Rezoning Transportation Analysis

Petition Number: #2022-183

Date	Description
03-23-23	First Review (PDM)
04-20-23	Second Review (PDM)
05-24-23	Third Review (PDM)

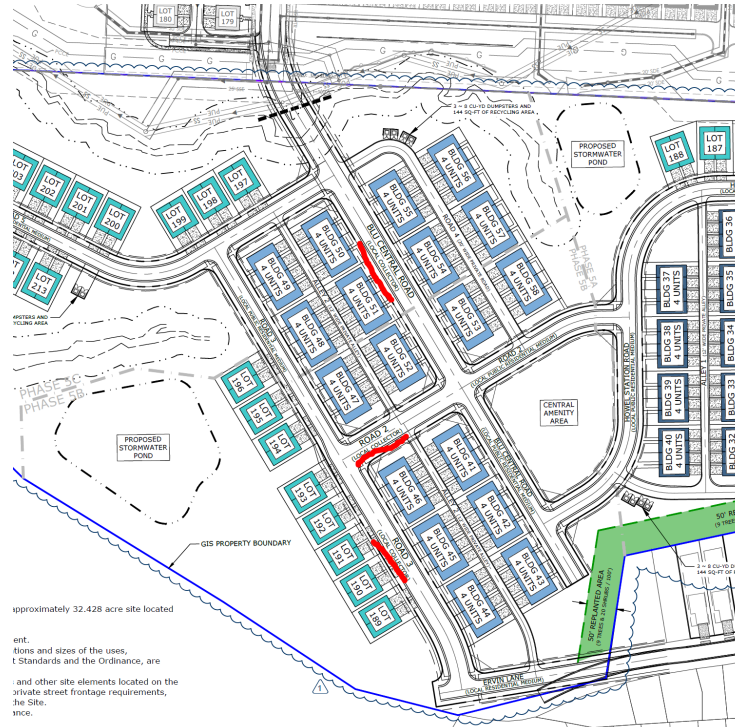
9. ~~Per coordination with Subdivision, revise site plan to provide a public north/south street in the location below.~~

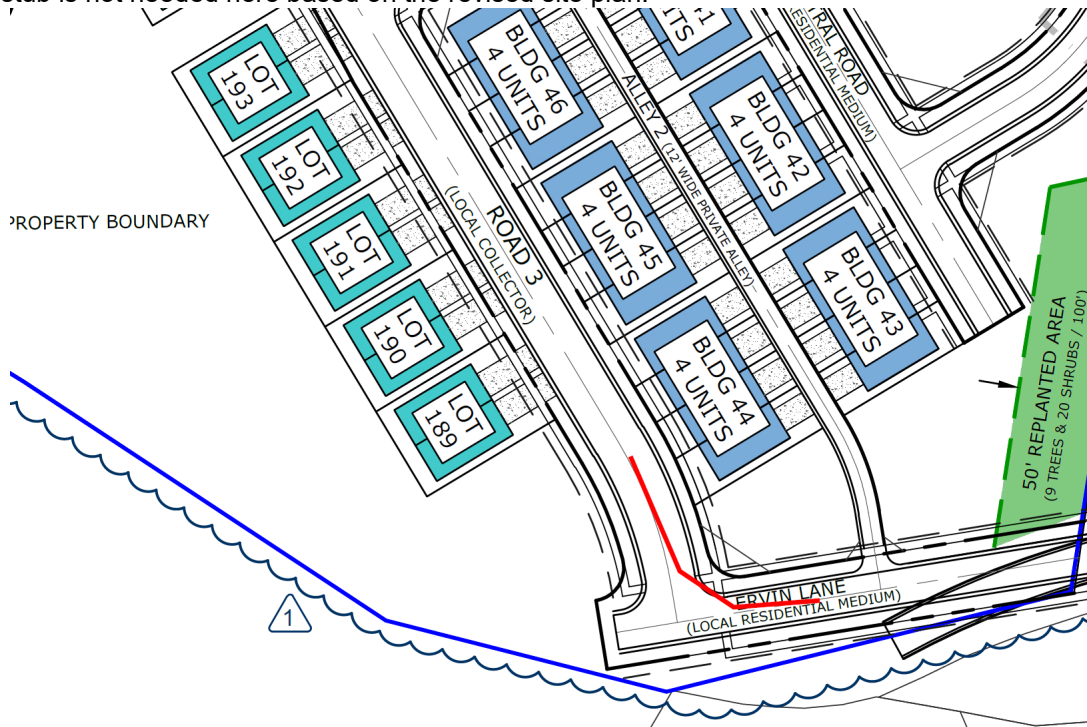
6. **Outstanding Comment from 03-23-23:** Add a conditional note specifying "A Right-of-Way Encroachment Agreement is required for the installation of any non-standard item(s) (irrigation systems, decorative concrete pavement, brick pavers, etc.) within a proposed/existing City-maintained street right-of-way by a private individual, group, business, or homeowner's/business association. An
